Recommendation Report for Planning Permission for Works or Extension to a Dwelling

REF NO: AW/2/26/HH

LOCATION: 17A Fernhurst Gardens  
Aldwick  
PO21 4BA

PROPOSAL: Proposed side dormers and single storey extension.

Proposed East Elevation

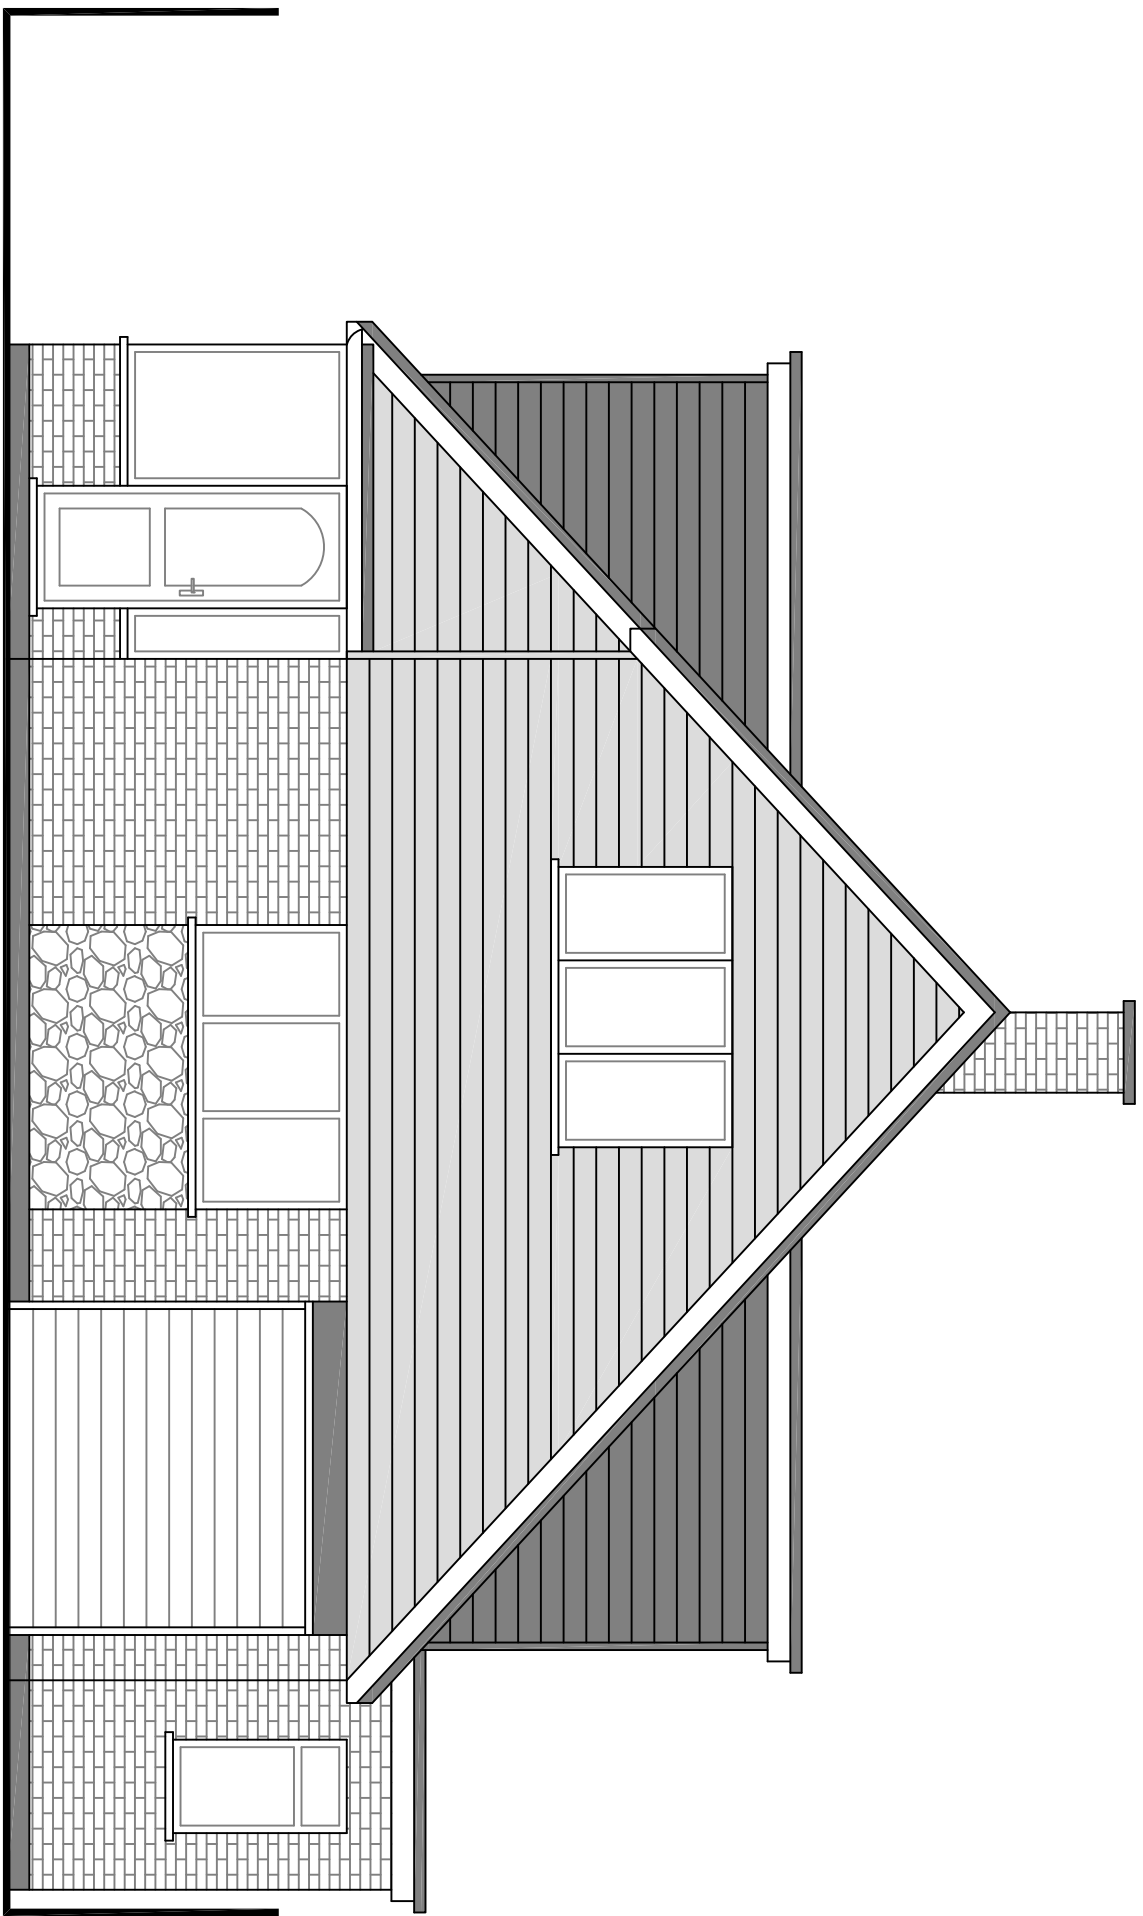
The proposed dormers would be highly visible within the street scene. The additional bulk would appear dominant, and the resulting flat roofed form would not reflect the character of the original dwelling or the surrounding area. Consequently, the overall massing would appear visually prominent and somewhat obtrusive, resulting in a degree of harm to the visual amenity of both the dwelling and the wider area.

However, the two side dormers would be positioned symmetrically within the roof slope, which would mitigate some of this harm. Their design would also reinstate the original eaves line and the maximum ridge height would not be altered as part of the proposed development. It is further noted that dormers of a comparable scale are present within the surrounding streetscape, therefore, the proposal would not appear out of keeping with the emerging character of the area. Additionally, dormers of similar scale could be constructed under permitted development, which would give rise to a comparable level of impact. In the absence of any historic planning condition removing permitted development rights from the property, this fallback position represents a material consideration in the assessment of the application.

A window serving the side extension is proposed at the front elevation (east), facing the frontage of the application site and the public highway. This window would therefore not result in any loss of privacy or overlooking.

Proposed Ground Floor Plan

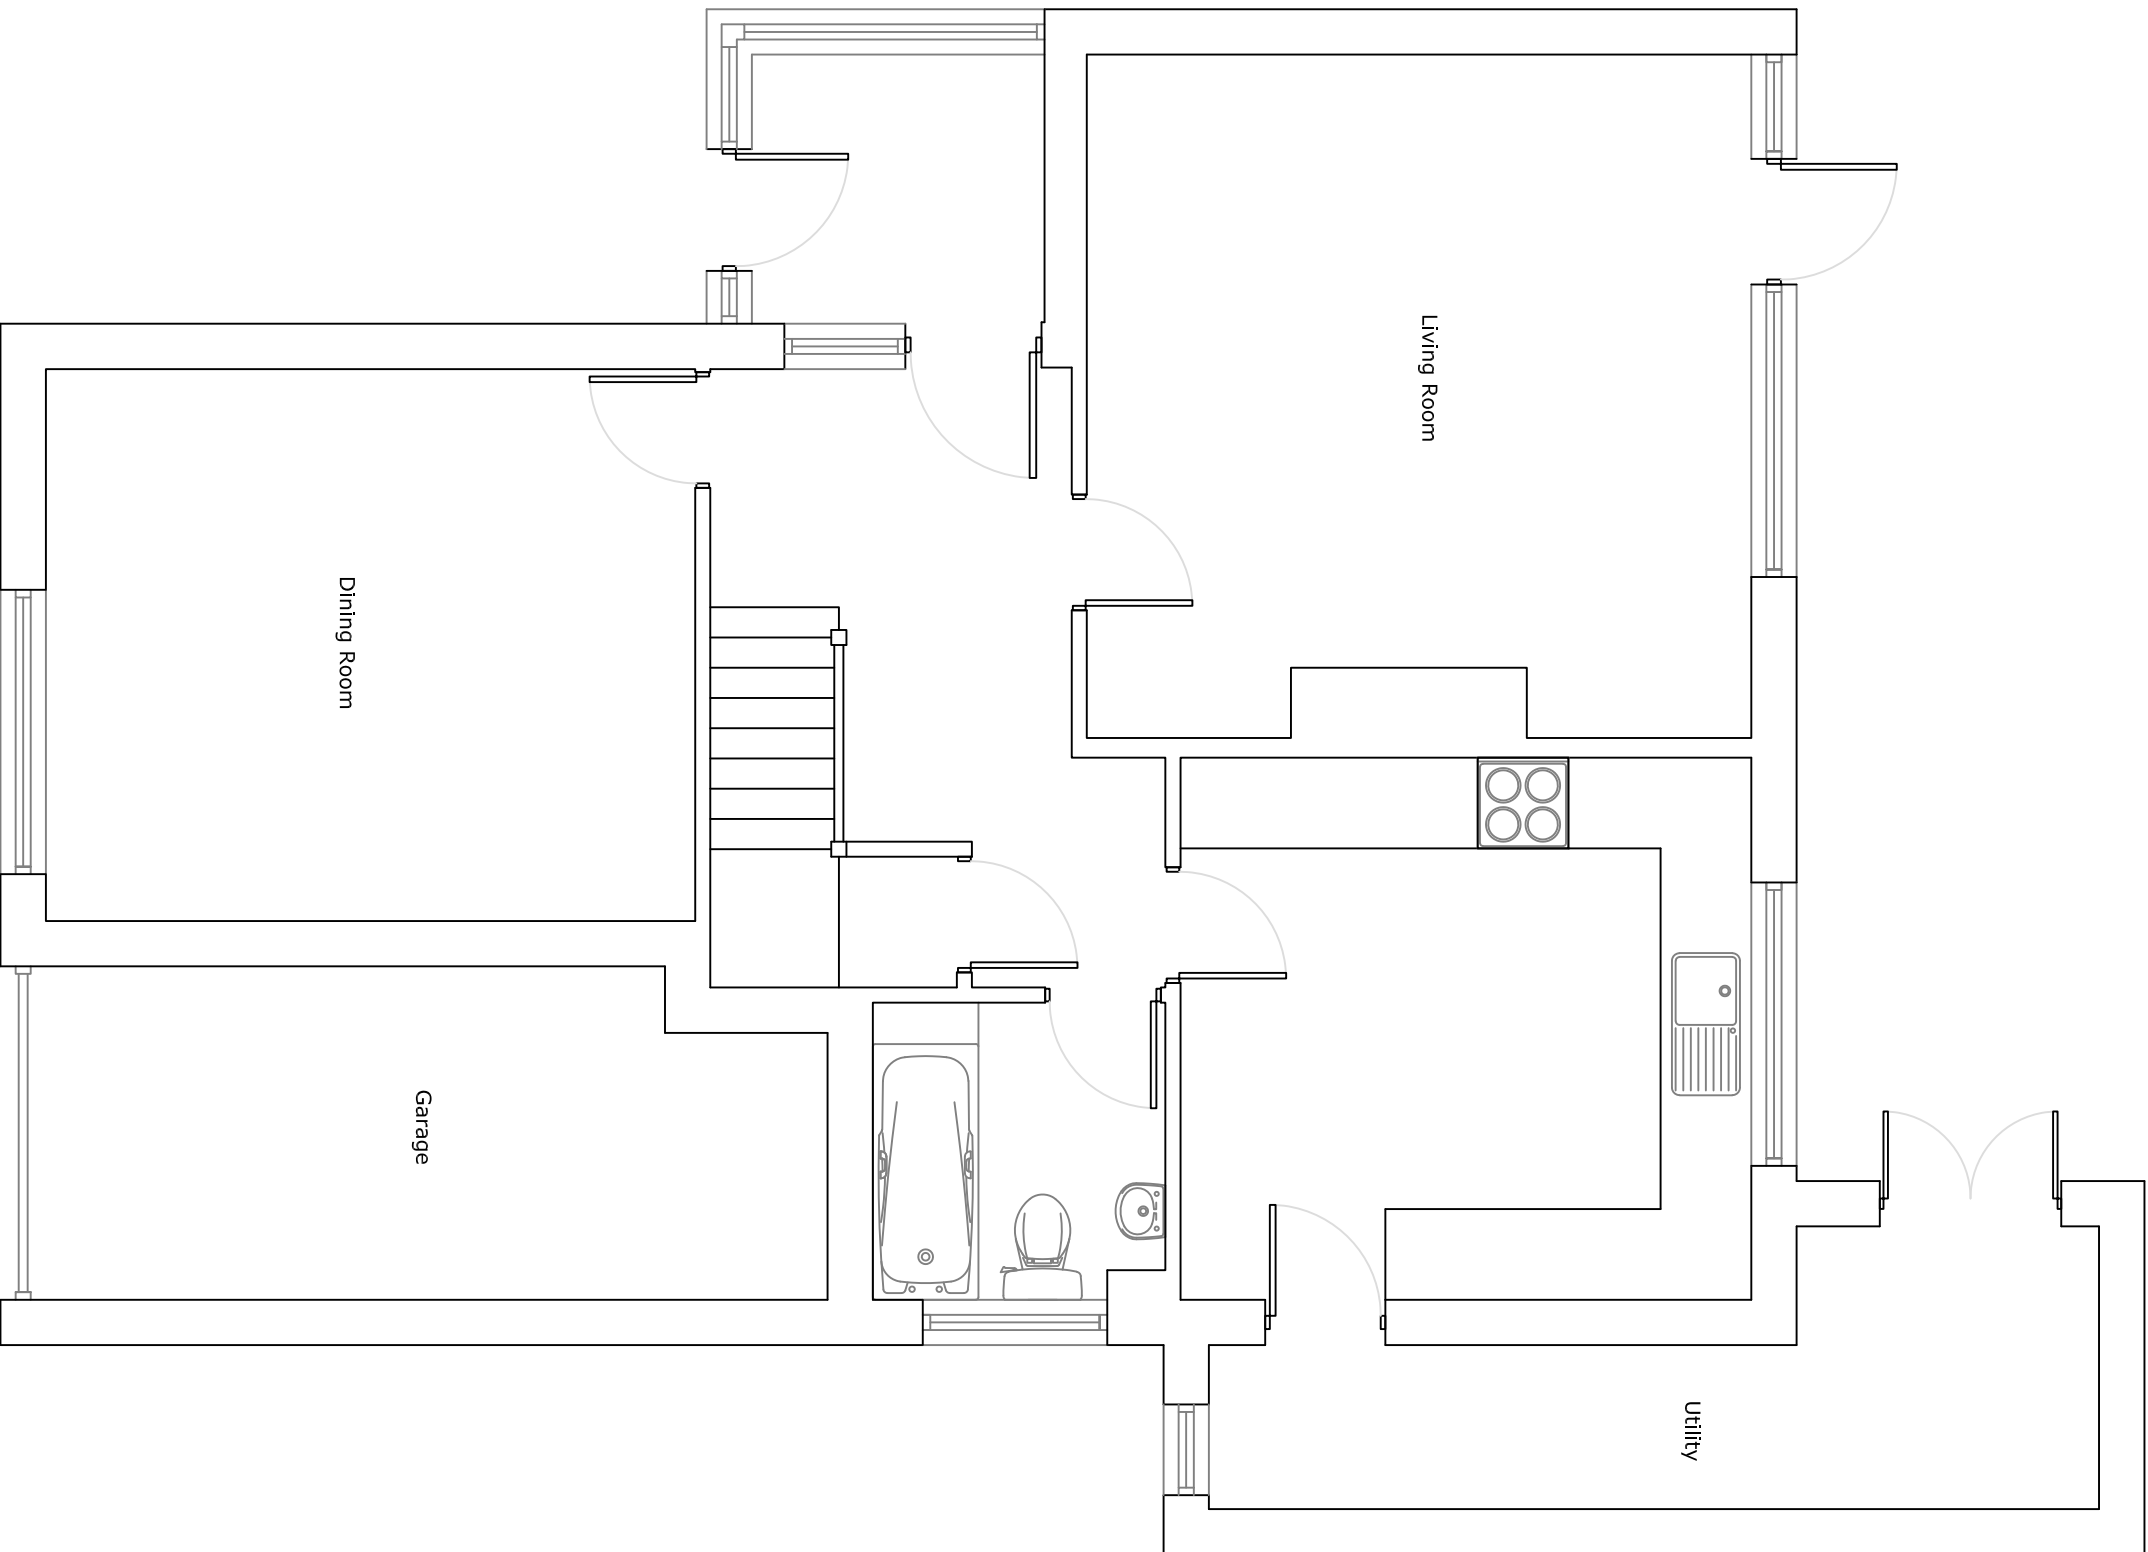
The proposed side extension would be set back approximately 7.7m from the front elevation. When viewed from the street, the extension would have a width of approximately 1.4m, widening to around 2.4m towards the rear. The extension would be constructed in brick to match the existing dwelling, ensuring visual integration with the host building in accordance with the Arun Design Guide (ADG). The extension would feature a flat roof design with a maximum height of approximately 2.8m and would incorporate a window consistent in style with the existing fenestration within the front elevation, along with a patio door providing access to the private garden to the southern flank of the extension. As such, the proposed side extension would not result in harm to visual amenity and therefore is in accordance with Arun Local Plan policy D DM4 and the ADG.

The side extension would be set in approximately 0.15m from the northern side boundary. The adjoining northern neighbour benefits from an existing rear projection, and the proposed extension would not extend significantly beyond this built form. As such, the side extension would not result in significant overbearing or overshadowing impacts to the neighbour to the north. Due to its sitting, the extension

Proposed West Elevation

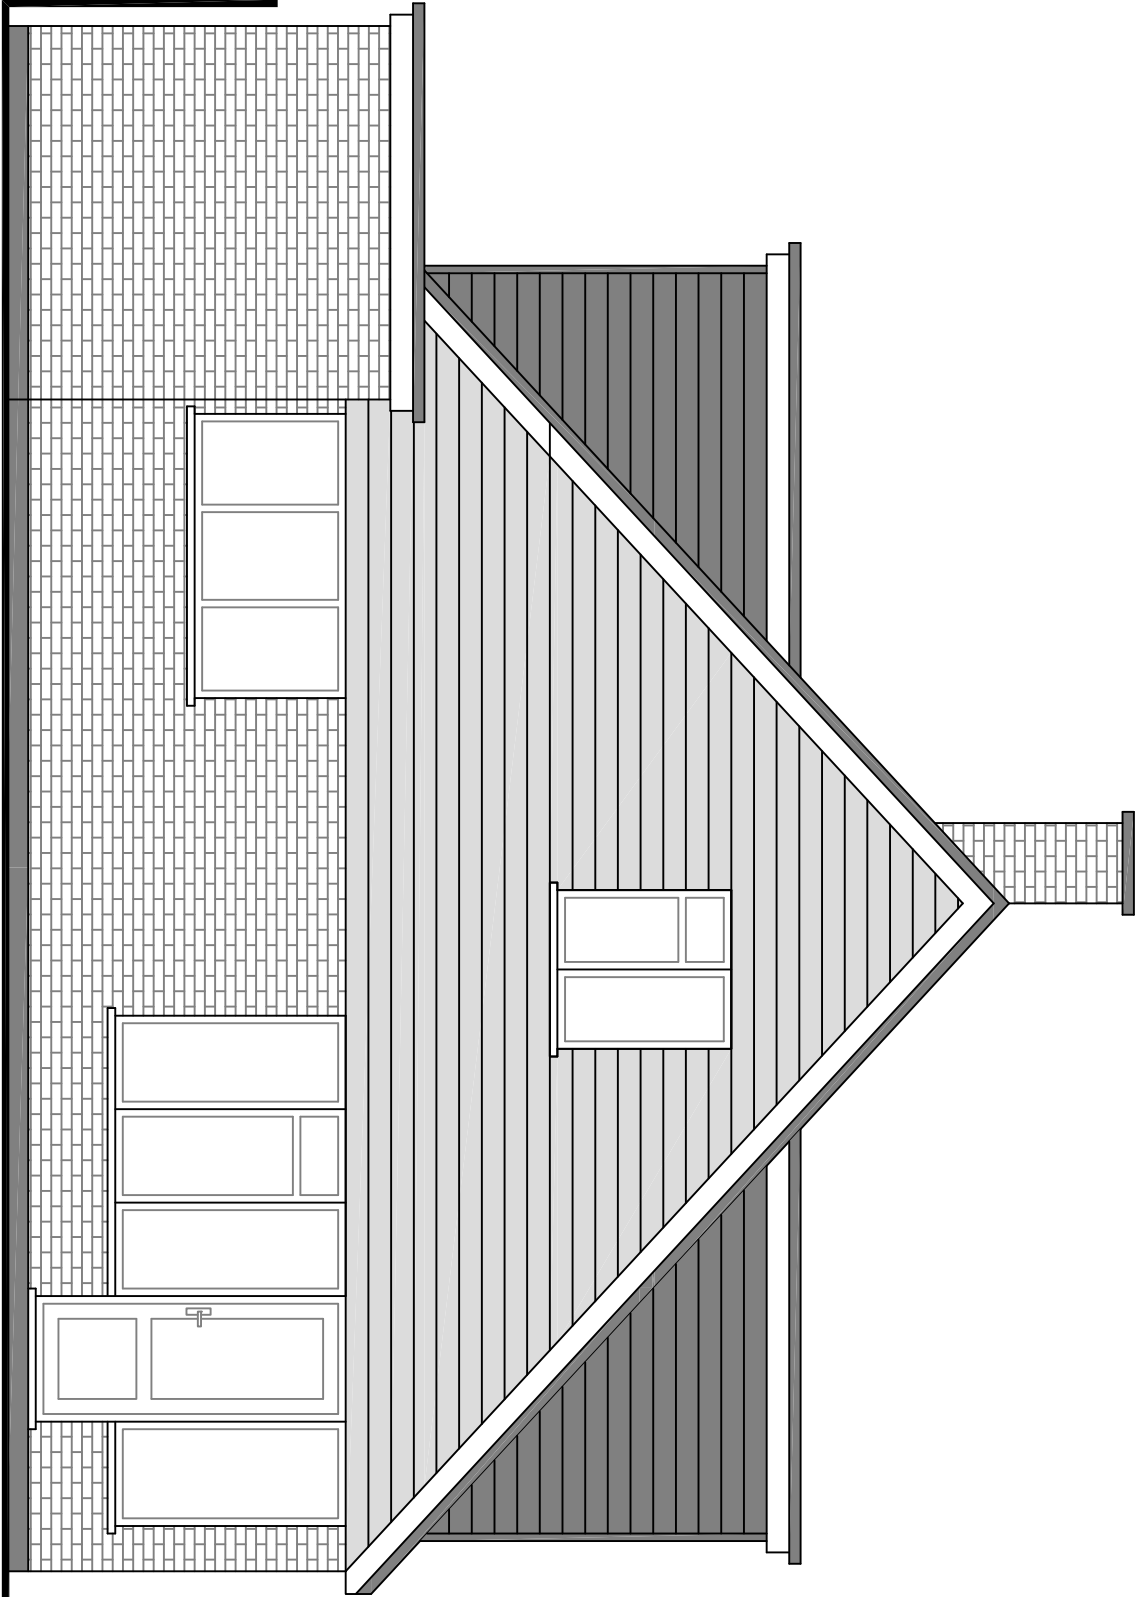
The proposed rear patio doors would be at ground floor level and it is noted that an existing three-pane window is already present on this elevation. Accordingly, the new doors would not introduce any additional overlooking of the property to the south.

Proposed South Elevation

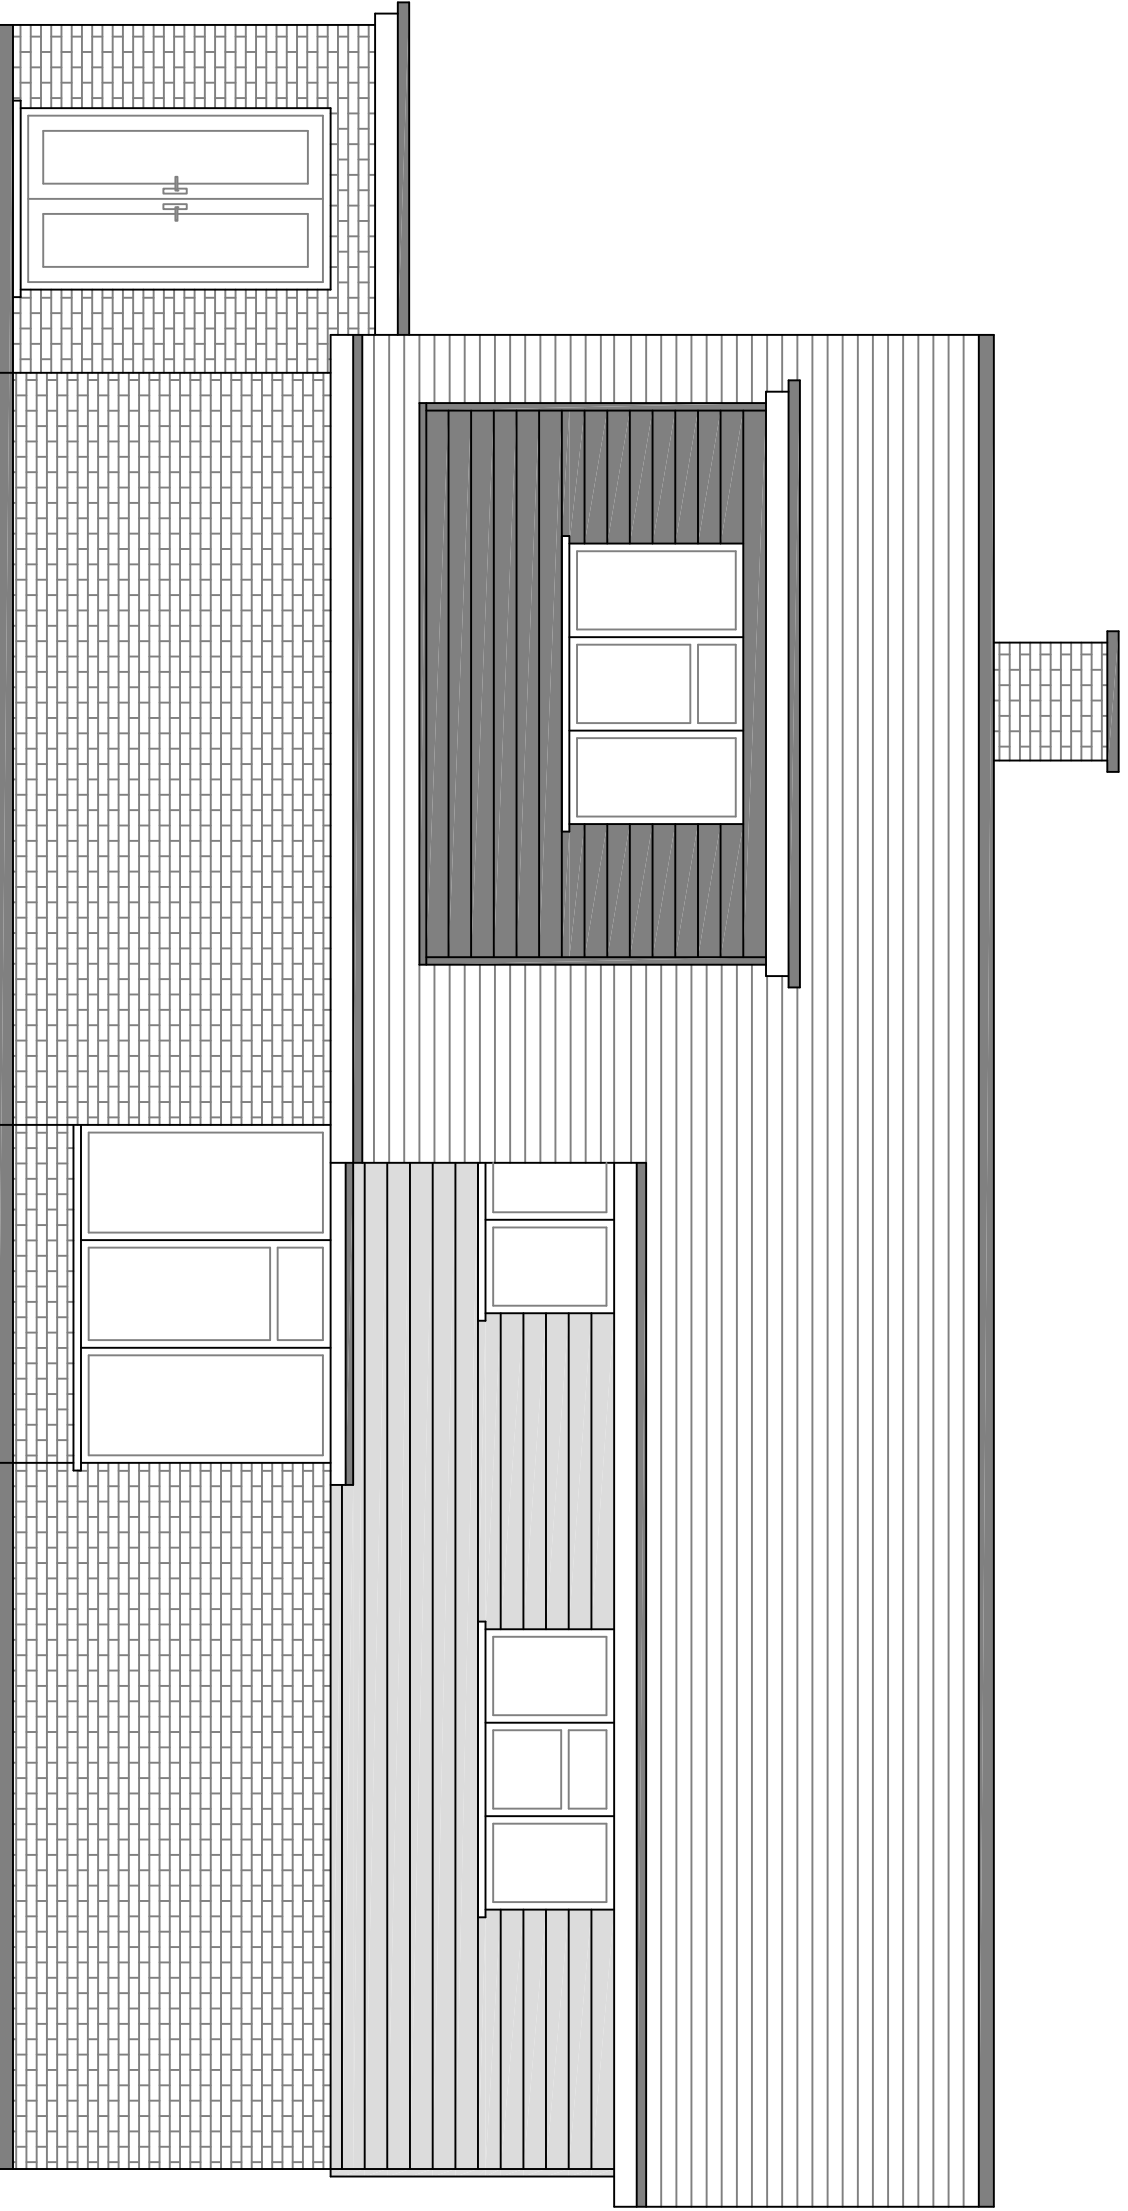
A dormer is proposed within the southern flank roof slope. The dormer would measure approximately 3.7m in width and 2.9m in depth, with a flat roof form and a maximum height of 2.5m. The dormer would be finished in materials to match the existing roof, ensuring visual integration with the host dwelling in accordance with the Arun Design Guide (ADG). It would incorporate one three-pane window in a style consistent with the existing fenestration and would serve the proposed bedroom.

The south (side) dormer would introduce one three-pane window on the first floor level. This window would provide oblique views towards two small dormer windows and a ground floor window of the neighbouring property, in addition to the neighbouring garden. It is noted there are already first floor windows on this elevation, and the introduction of the new opening would not materially increase overlooking beyond the existing situation.
